# A303 Sparkford to Ilchester Dualling Scheme TR010036

## 8.6 Draft Statement of Common Ground with Somerset Drainage Board Consortium

**DRAFT STATEMENT OF COMMON GROUND**

Drawing Title
OUTLINE DRAINAGE WORKS PLANS
REGULATION 5(2)(p)
SHEET 2 OF 4

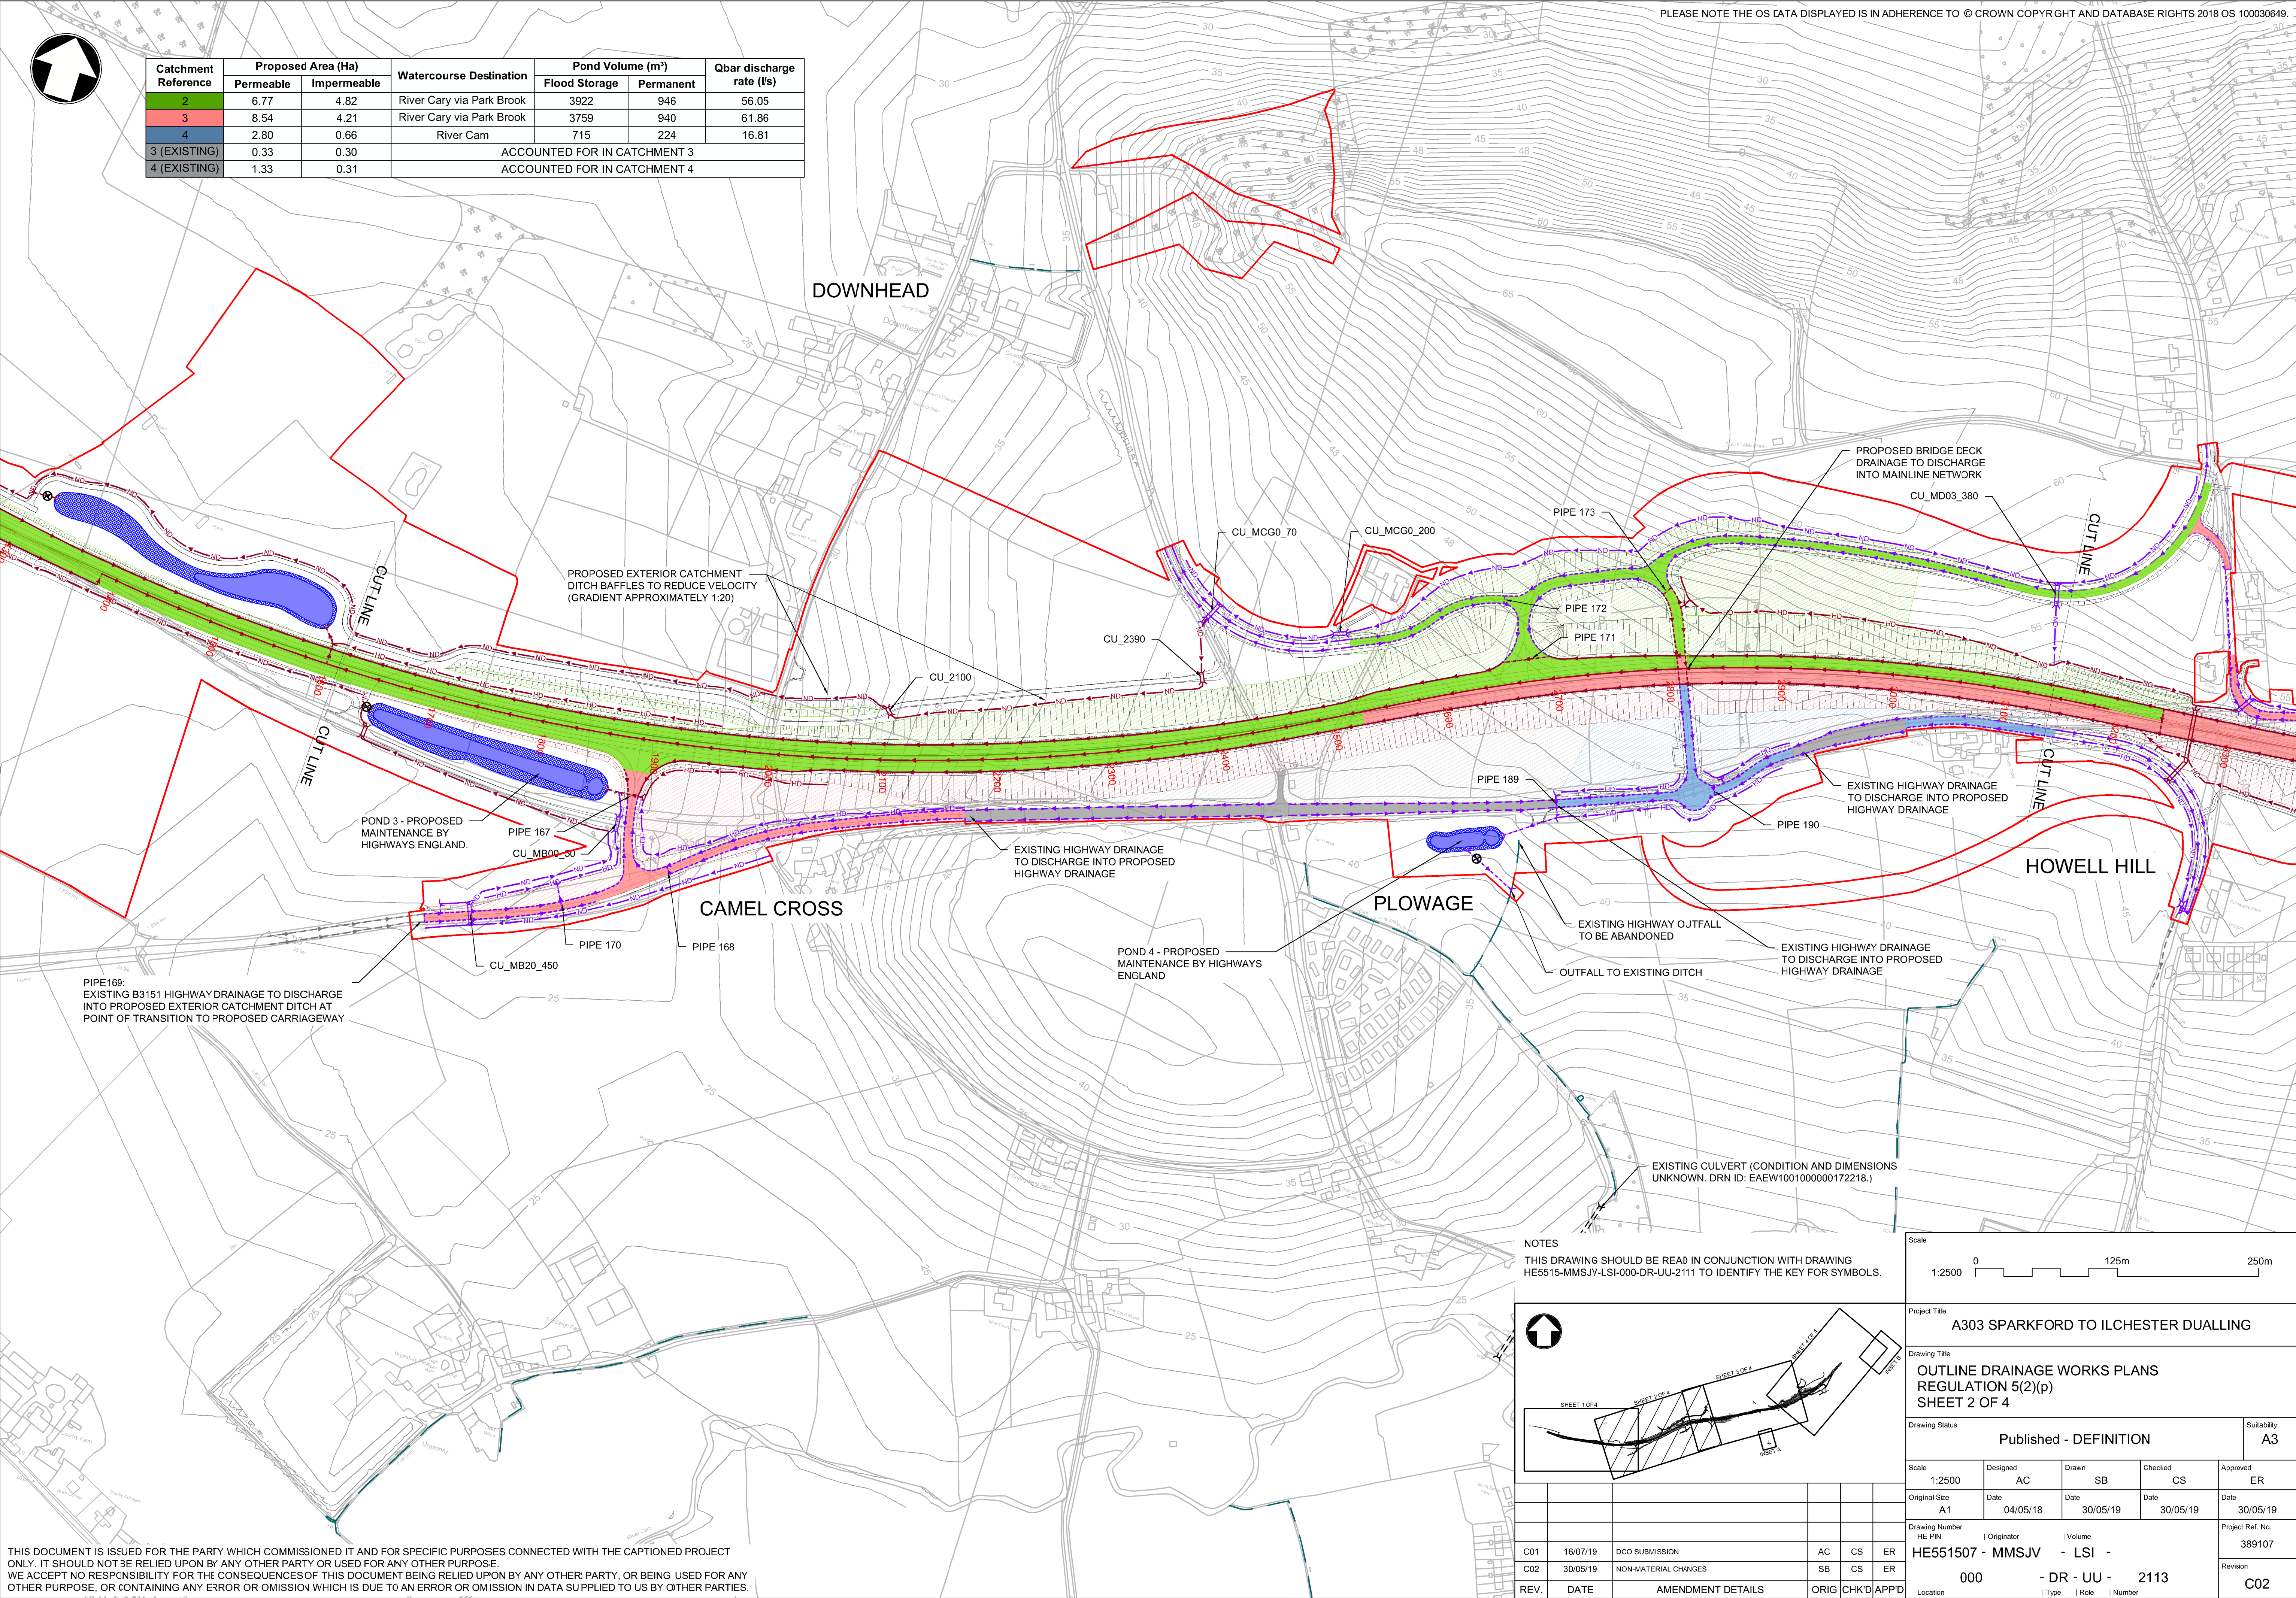
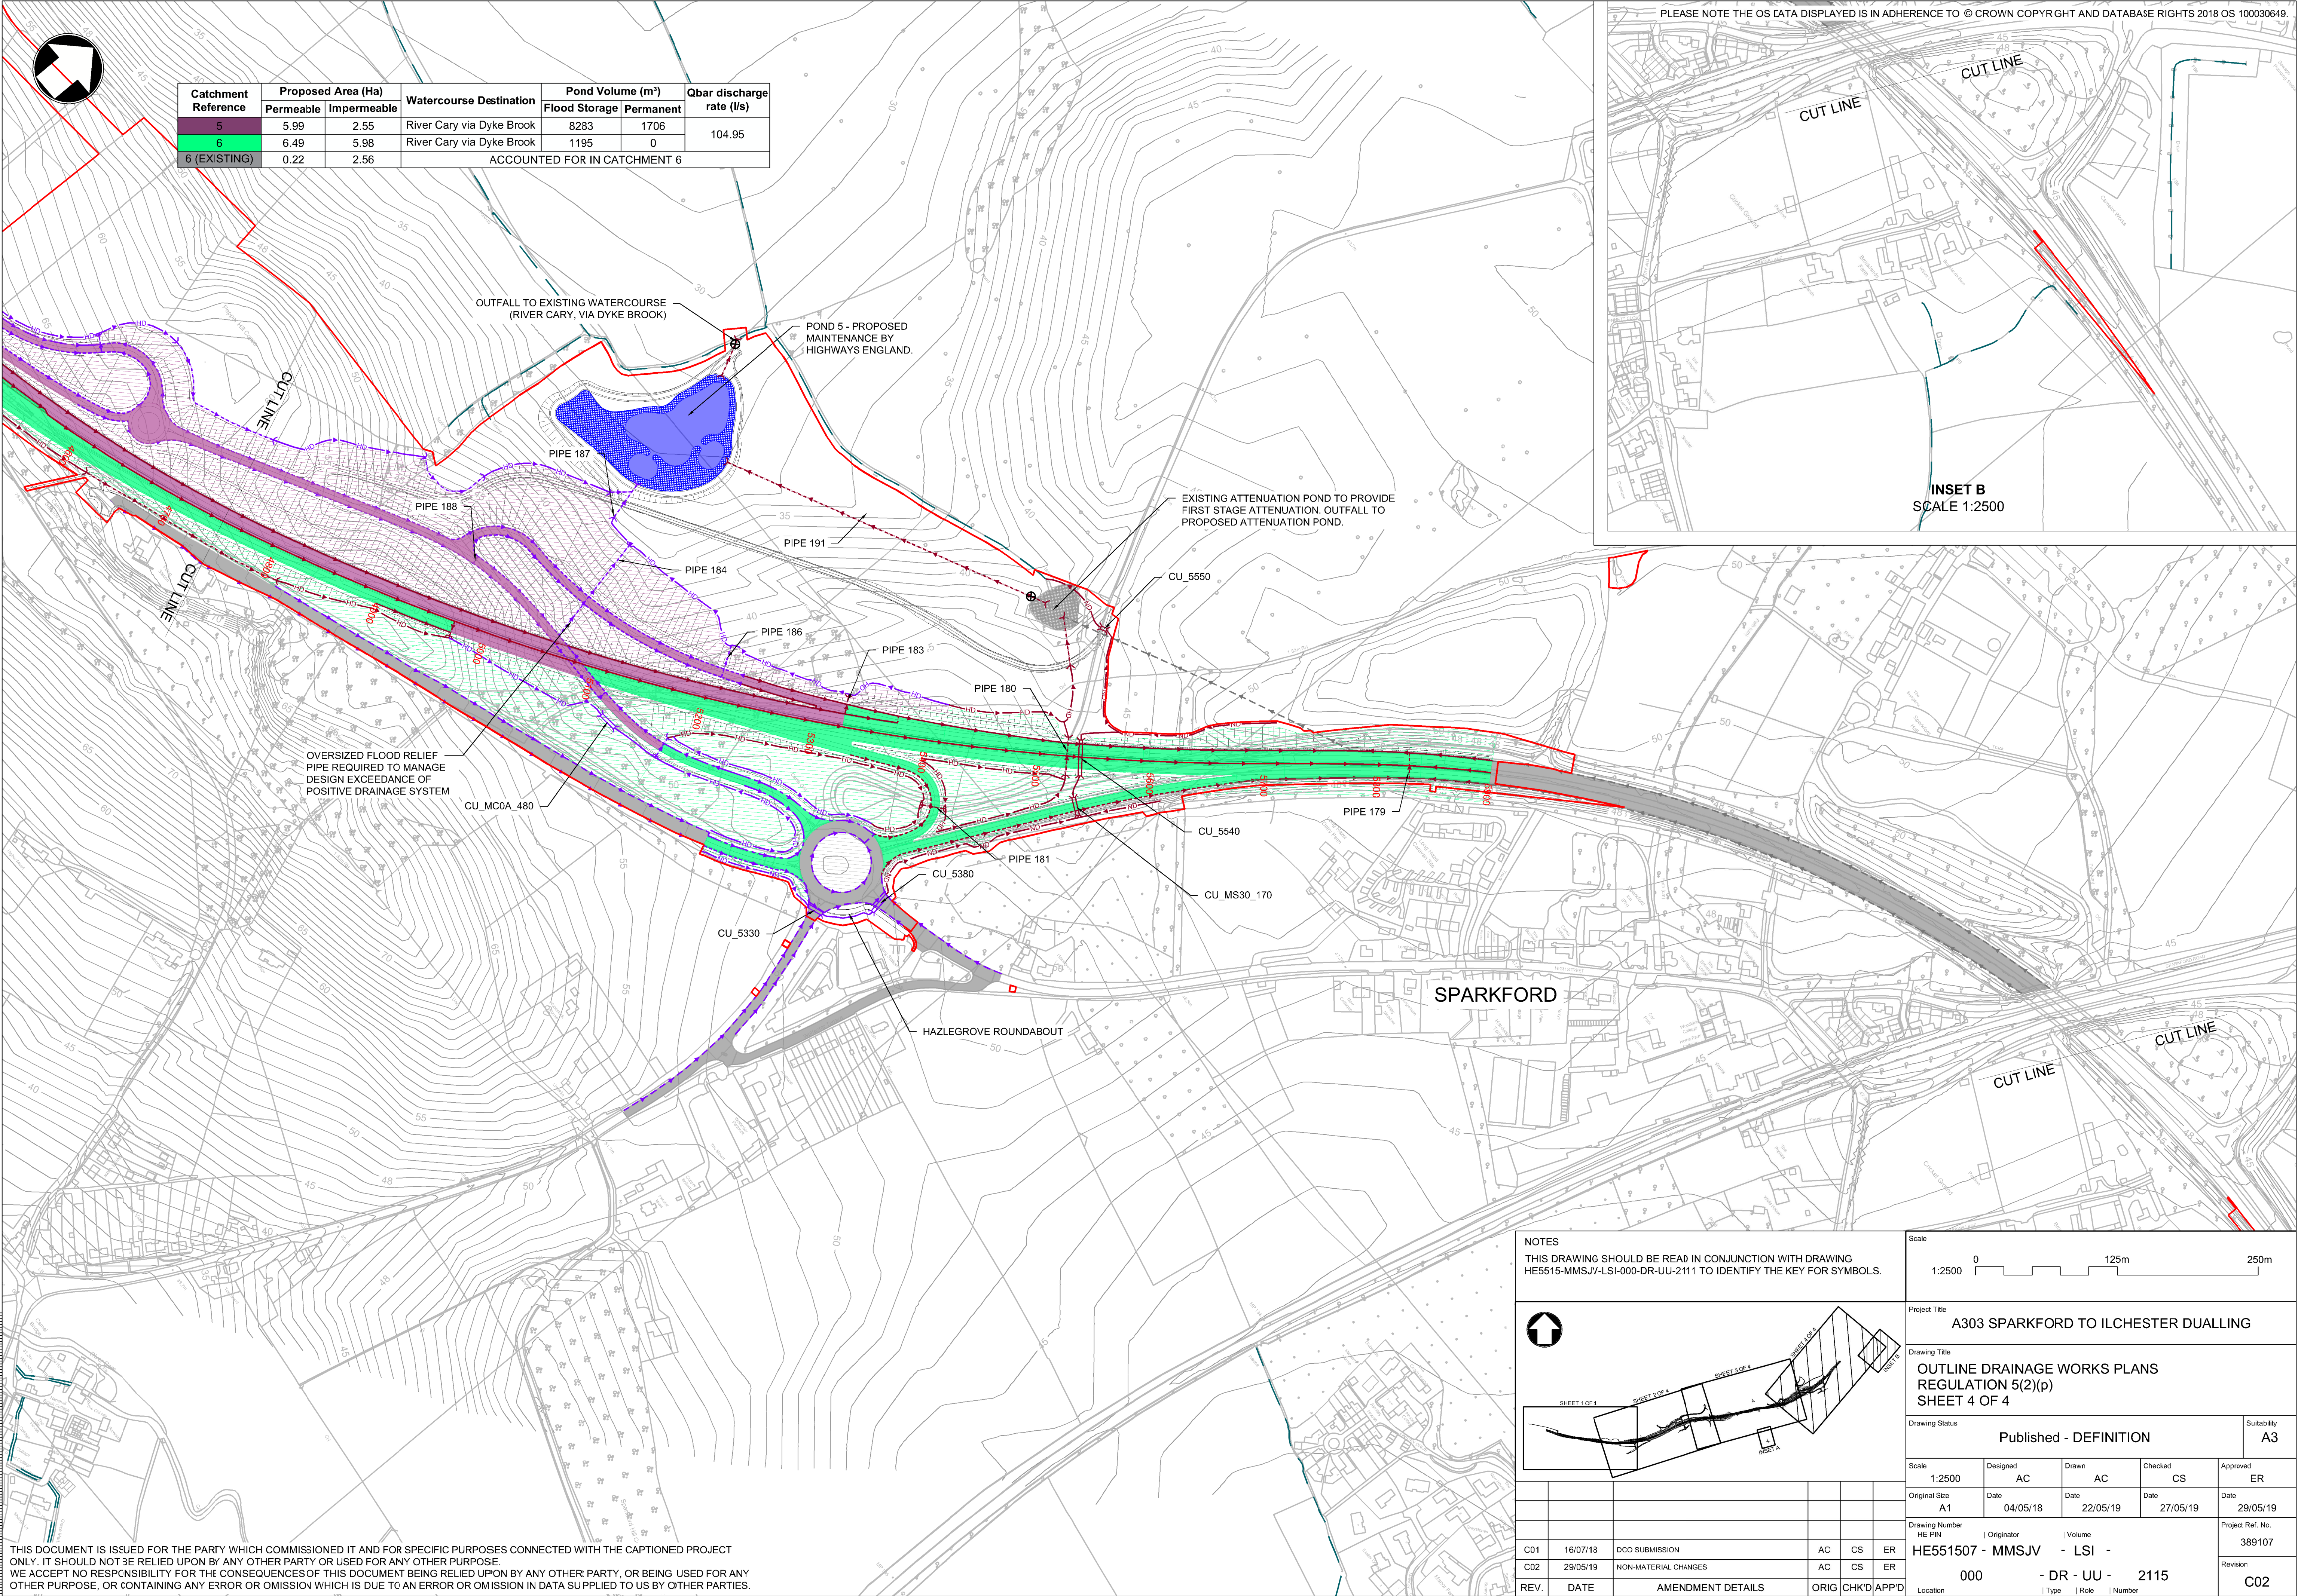
Topic	Stakeholder Comment	Highways England Response	Status
Water quantity	Confirmation is sought that the proposed design will control the overall volume, as well as the overall rate of runoff with sufficient attenuation provided.	Attenuation has been provided, with discharge limited to 1% annual exceedance probability (1 in 100-year event) plus 40% to account for the effects of climate change (Flood risk assessments: climate change allowances, Environment Agency), to no greater than the undeveloped rate of runoff, determined by the calculation of the mean annual peak rate of runoff for a greenfield site (Qbar).  Preliminary design discharge rates and volumes shown in Outline Drainage Works Plans (APP-106).	<b>AGREED</b>
Water quality	Confirmation is sought that the proposed pond design provides effective water quality treatment with the use of a permanent water level, and that this volume is sufficient in size.  It is recommended that the SuDS Manual (C753) is referred to in the calculation of these permanent volumes, as well as the detailed design of the forebays and vegetation that will be essential for water treatment.	A permanent water level has been provided for each of the proposed ponds. The volume of treatment has been provided in accordance with the SuDS Manual (C753) - '10-15 millimetres of rainfall depth falling over the contributing catchment'.  Accepted.  Appropriate planting has been considered as part of the landscaping assessment and design.  Attenuation feature discharge rates and volumes shown in Outline Drainage Works Plans (APP-106).	<b>AGREED</b>

Topic	Stakeholder Comment	Highways England Response	Status
		As in accordance with Outline Drainage Works Plans (APP-106).	
Maintenance and access	<p>There is concern that there is not adequate space provided for adequate and effective maintenance of the ponds and ditches.</p> <p>It is recommended that maintenance tracks are provided, ensuring connectivity to the ponds and ditches.</p> <p>To undertake a full de-silt of the ponds a maintenance strip greater than 4m is required. Further information needs to be supplied on this at the detailed design stage.</p>	<p>A grassed 4 metre maintenance strip has been provided around each pond and along each ditch. Additional access tracks have been provided to provide access to the ponds.</p> <p>As in accordance with Outline Drainage Works Plans (APP-106).</p>	<b>NOT AGREED</b>
	<p>There is concern that the maintenance tracks do not provide access to the control structures, which would need to be maintained and accessed in the event of a large pollution incident.</p>	<p>Accepted.</p> <p>The ponds and maintenance tracks have been redesigned to provide access to these structures.</p> <p>Access shown in Outline Drainage Works Plans (APP-106).</p>	<b>AGREED</b>
